Planning and Regulatory. G.Mansfield.  
Reference: 4921880  
Phone: 02 4974 2767

25 September 2014

**NEW SPACE PROJECT, UNIVERSITY OF NEWCASTLE (SSD 6457)  
409 HUNTER STREET AND 300 KING STREET, NEWCASTLE AND 20 LAMAN  
STREET COOK HILL.**

The submitted application and Environmental Impact Statement (EIS) have been reviewed by Council officers and the following comments are offered for your consideration:

DRAWING TITLE
PLAN - GROUND LEVEL

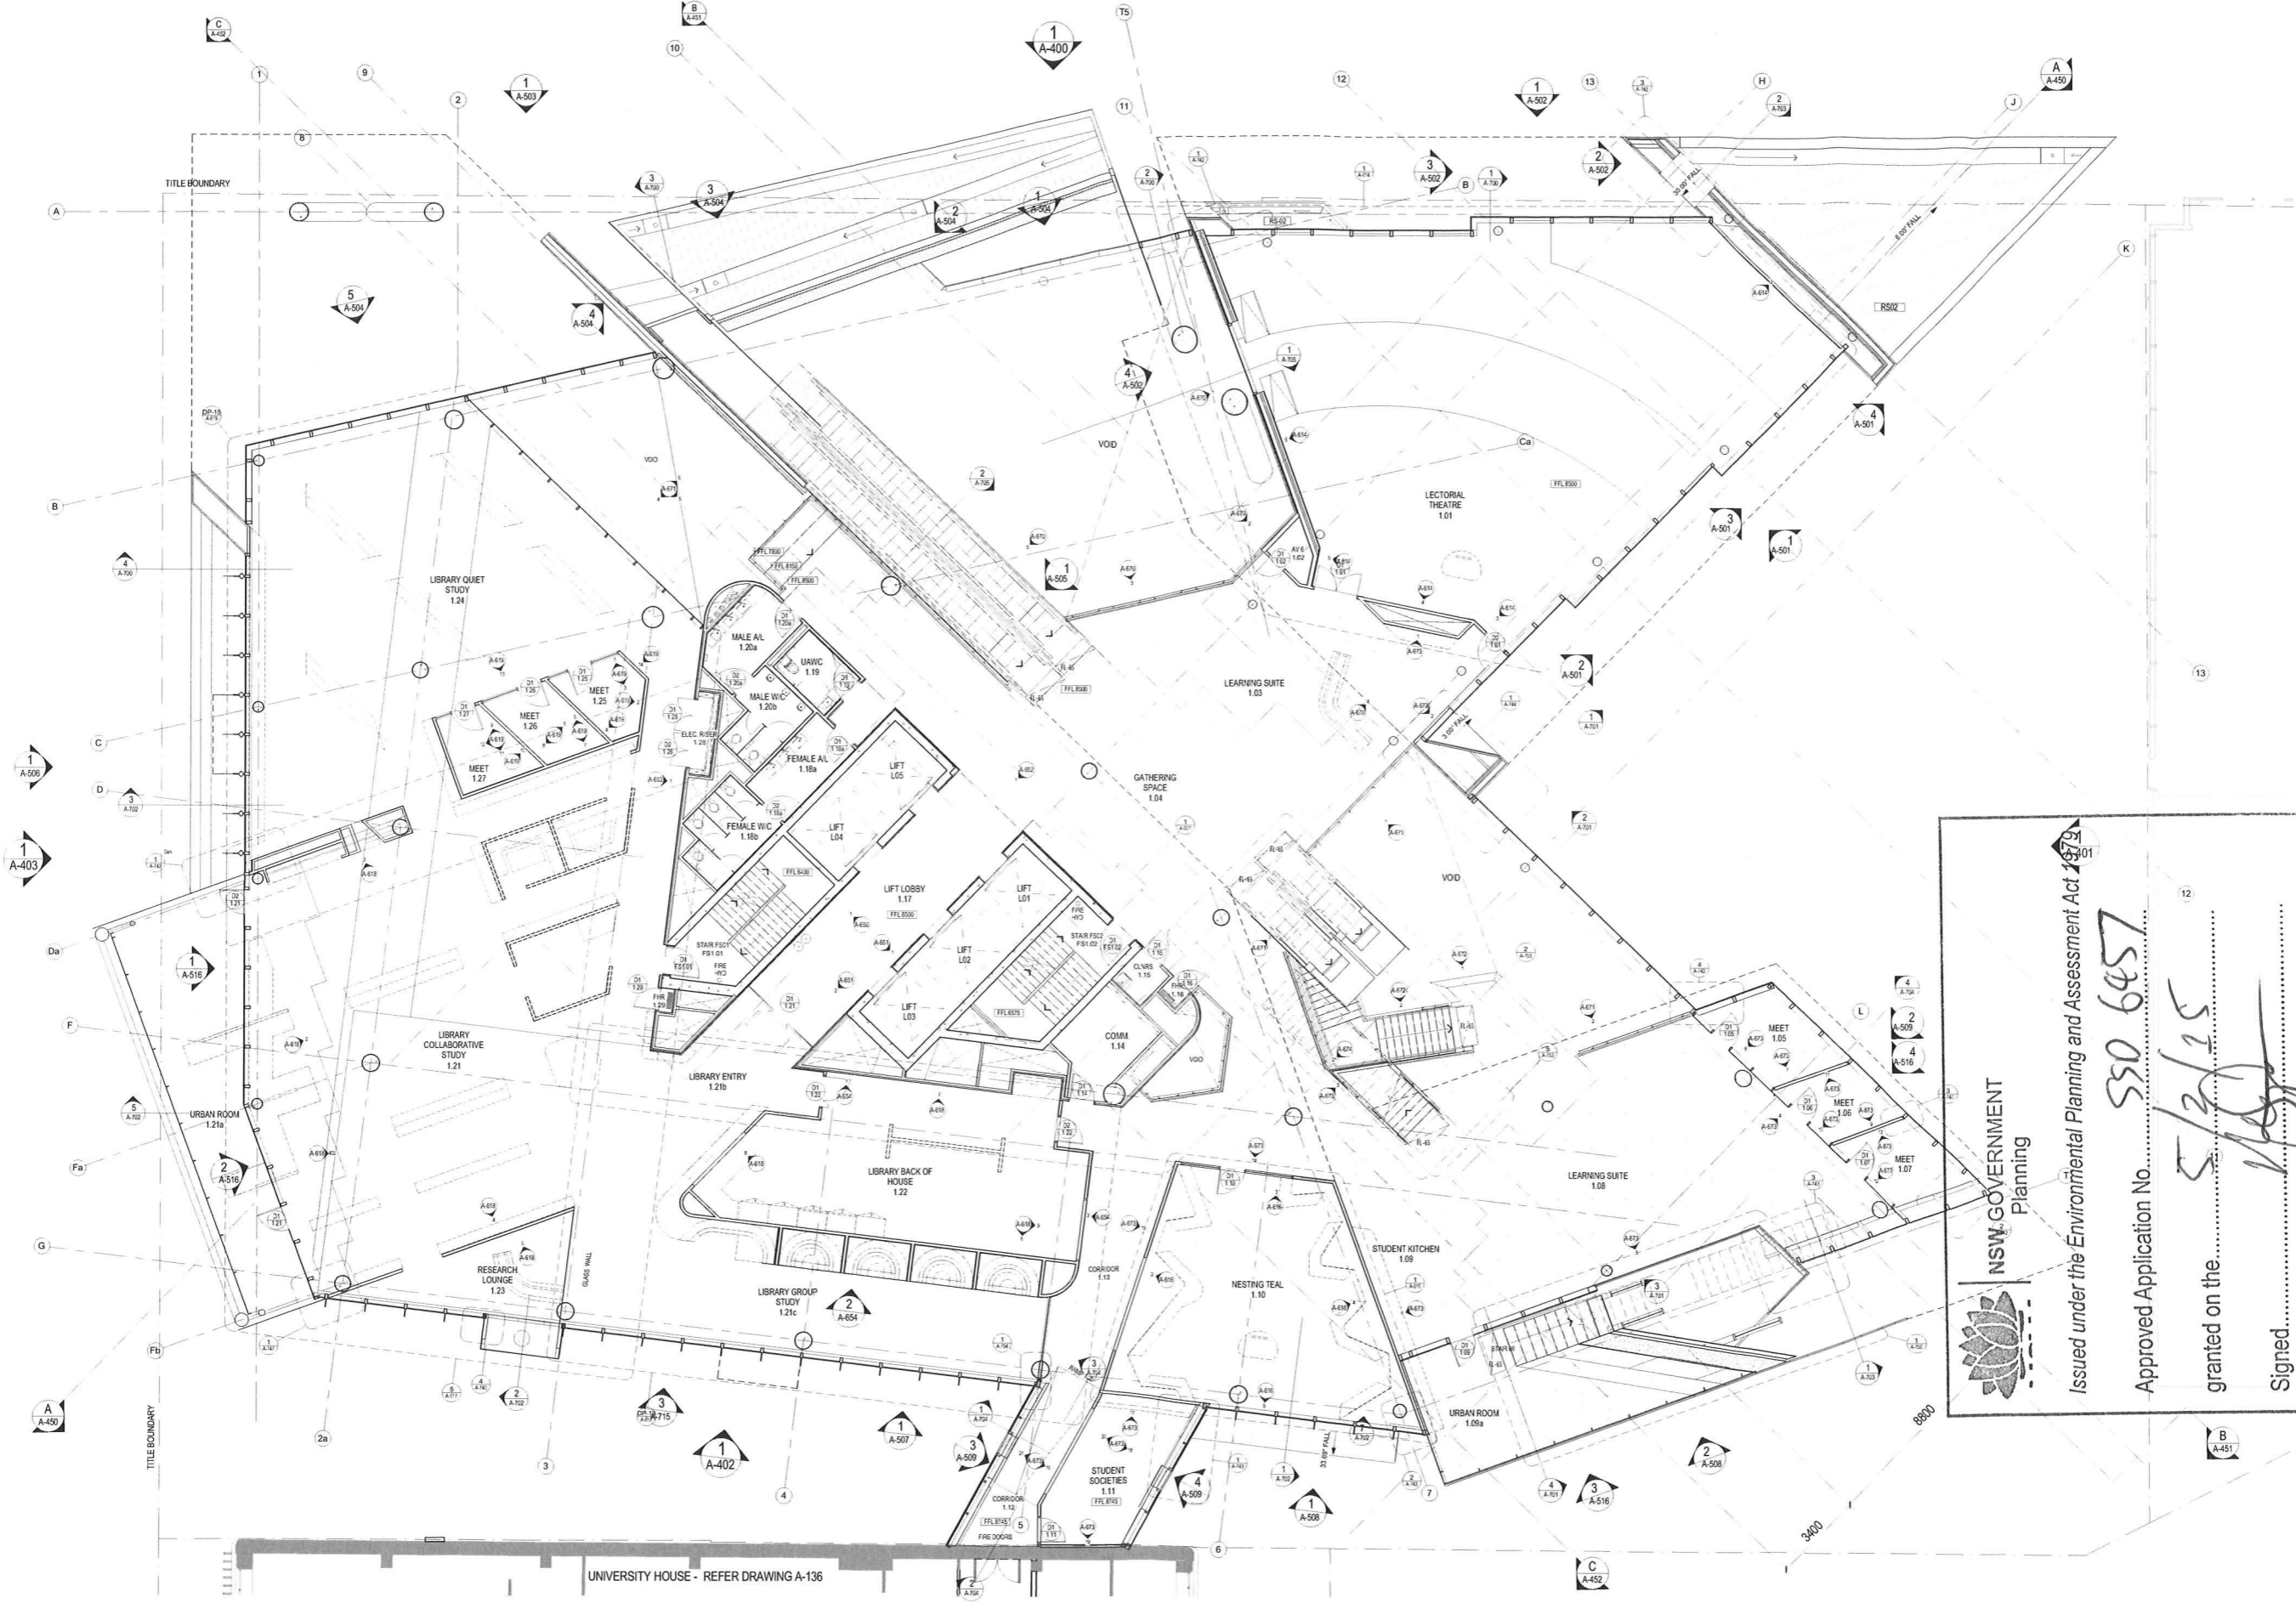
- The provision of a set down bay in front of the subject site (presumably for taxis) and the provision of motorcycle parking areas. (These facilities should be provided on-site so that Council is not burden with the ongoing maintenance costs).

The proposed treatment of the footpath and street furniture location and type for Auckland and Hunter Streets is required to be consistent with the requirements of Council's City Centre Technical Manual (CCTM). Prior to submitting any application under the *Roads Act 1993* for construction within the road verge, the applicant (i.e. University of Newcastle) is to consult with Council's City Centre Team.

1. Street trees are to be selected from the CCTM.
2. 'GARAKK' or aboriginal words used within paving for the development are to be confined within the subject site and are not to extend onto Council land. Etching in the footpath is not permitted in this location.

DRAWING TITLE
CONSERVATORIUM
CAR PARK

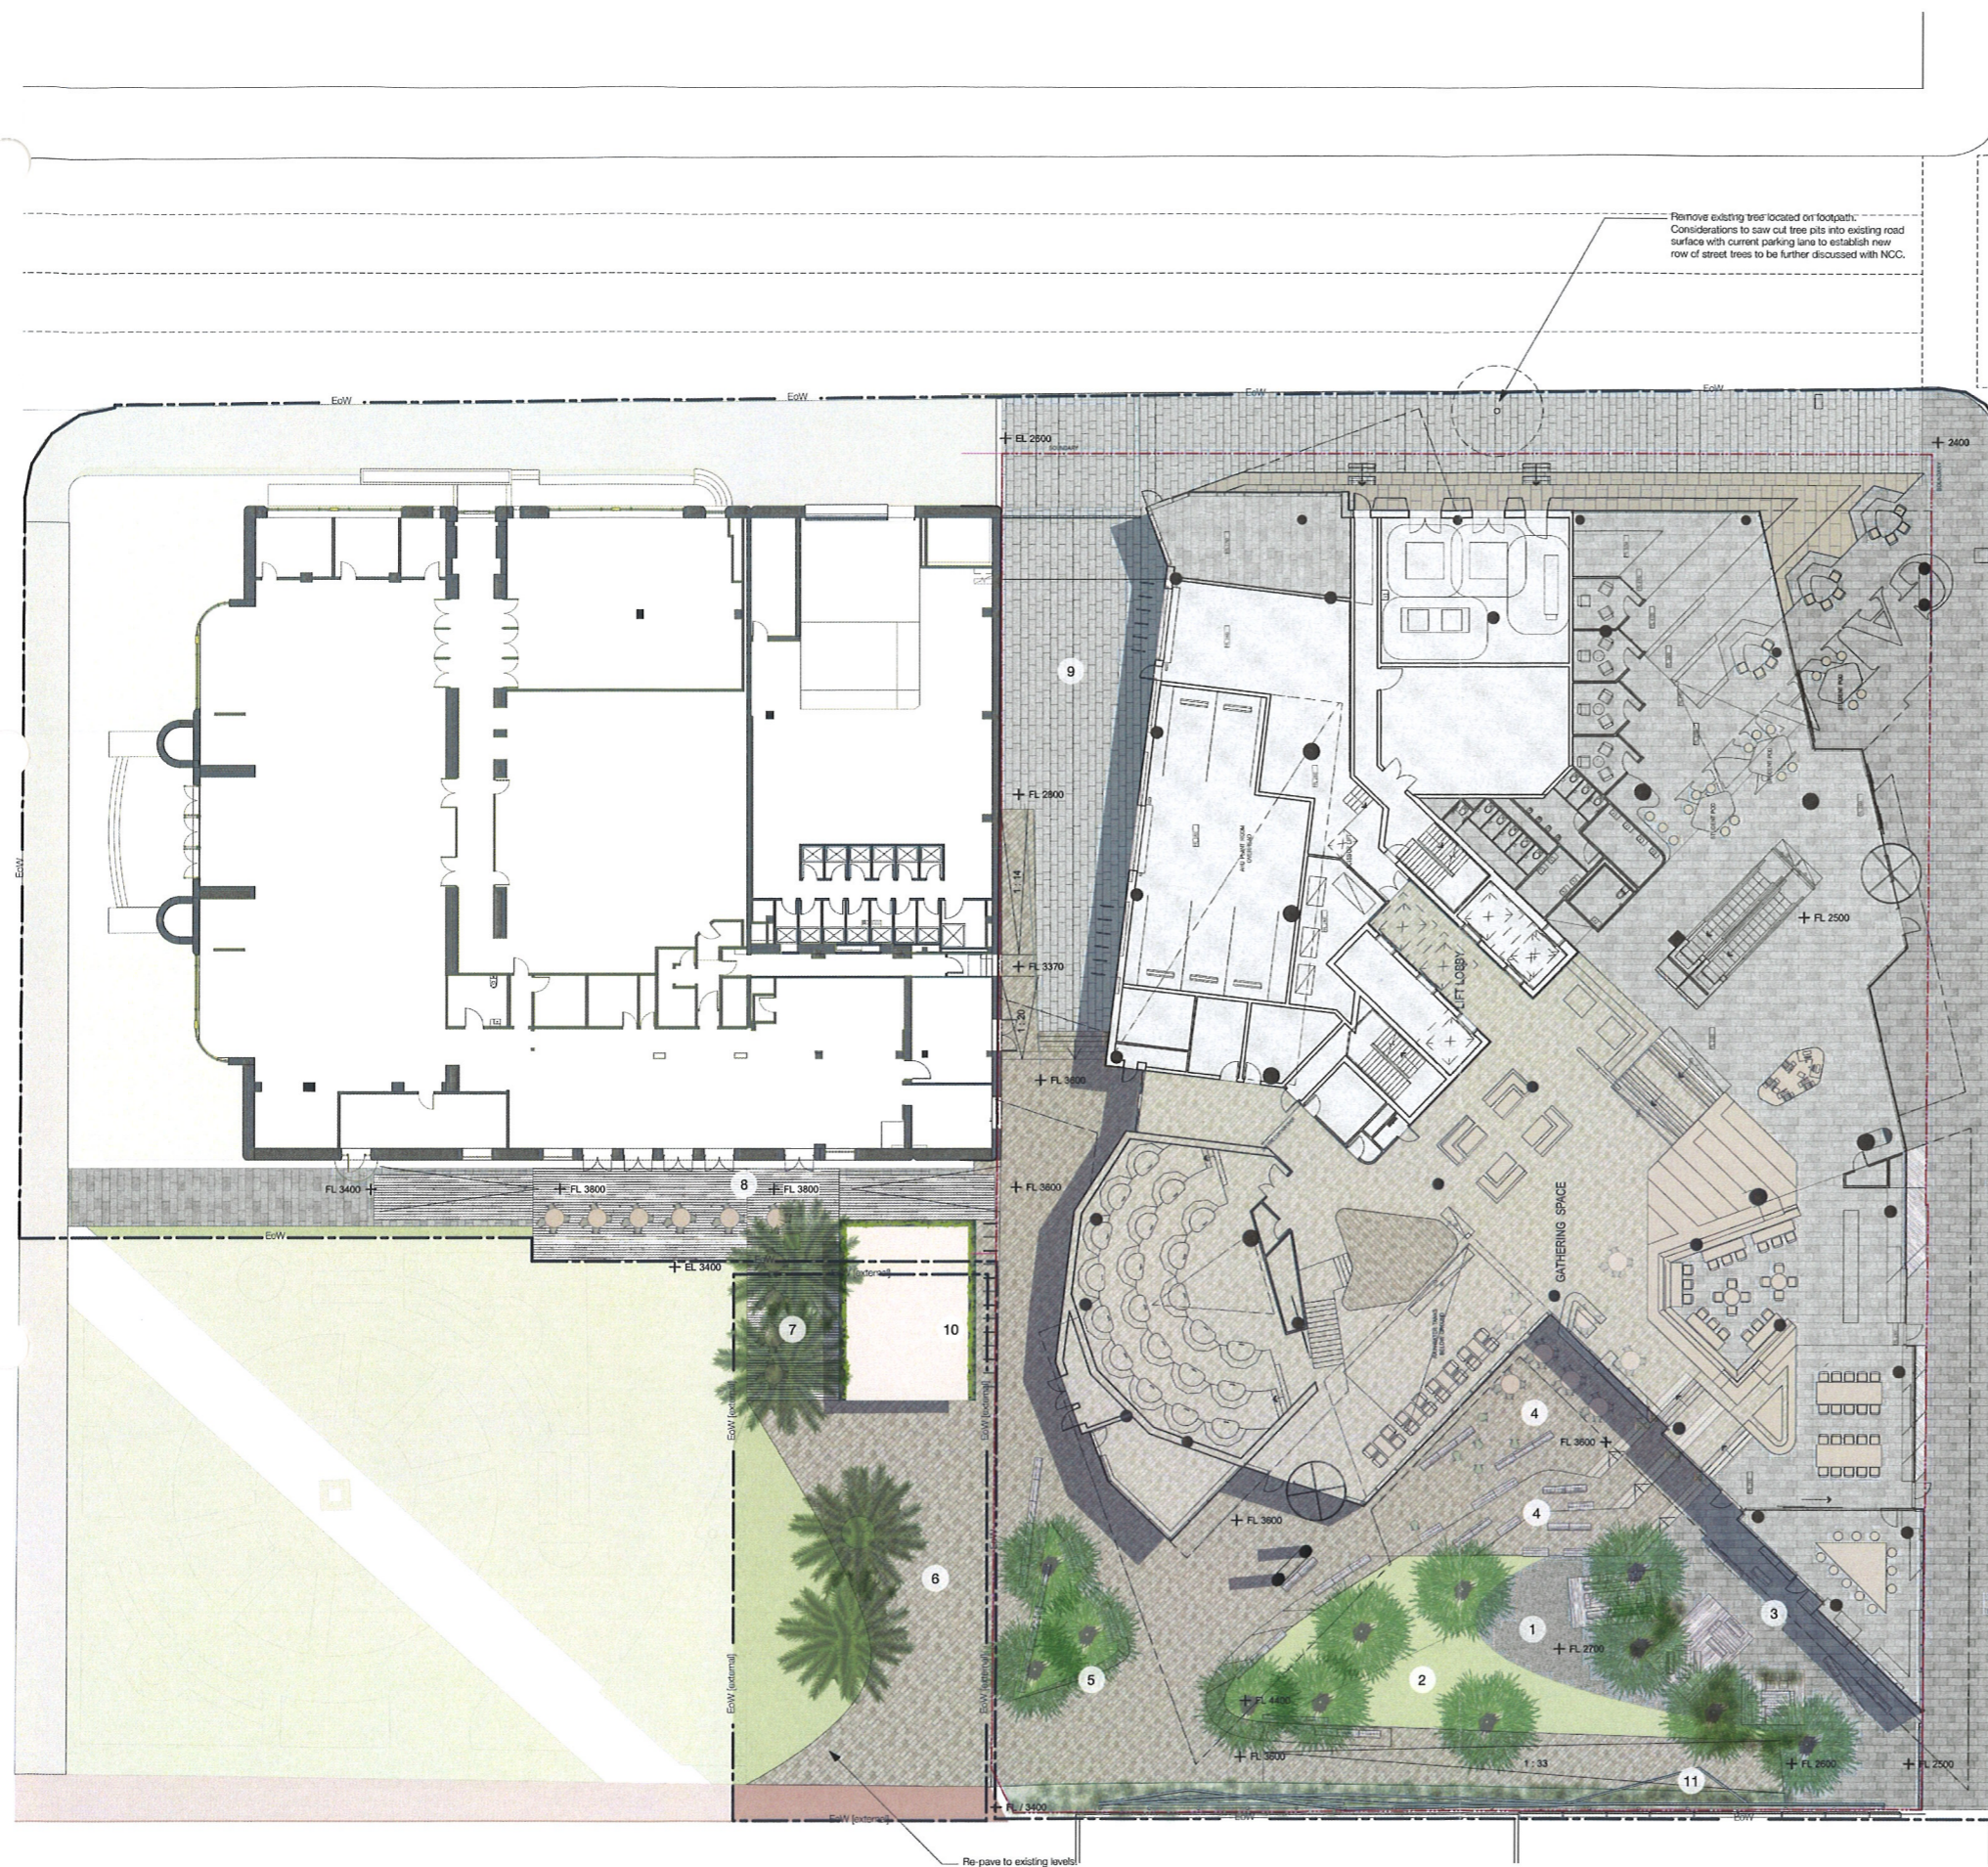
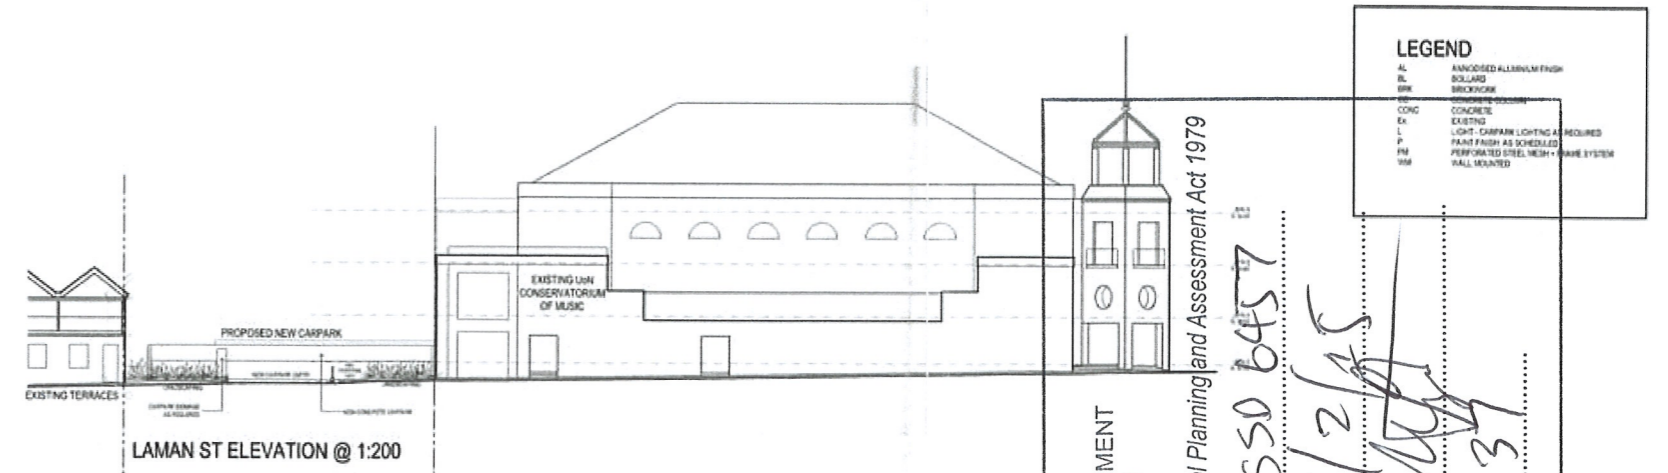
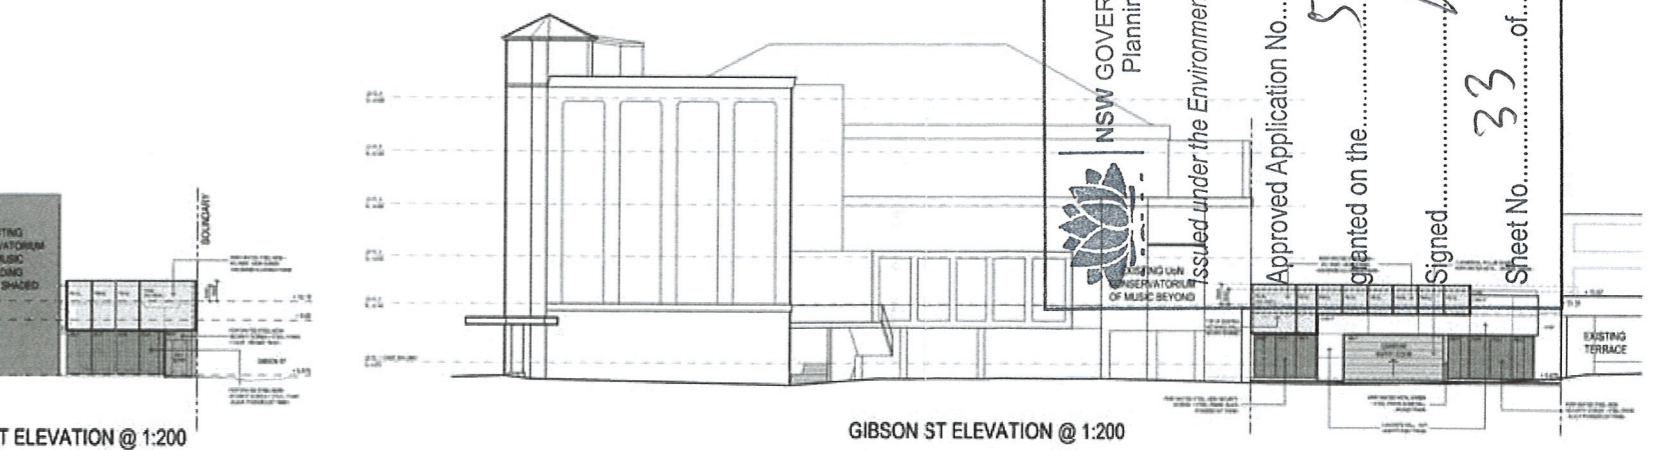
1. The report is considered to be inadequate as it only considers the security risks to the *NeW Space* building, no consideration has been given to the risks associated with the use of the enlarged car park in Laman Street and the personal safety of

The car park between Gibson and Laman Streets is zoned R3 Medium Density Residential under the provisions of the Newcastle Local Environmental Plan, 2012. Although the development is permissible in the zone, it is not considered to be consistent with the zone aims and objectives. The upgrading of the car park, as outlined the EIS, entrenches the non residential land use of the site and does not meet the strategic direction of the NLEP for this location.
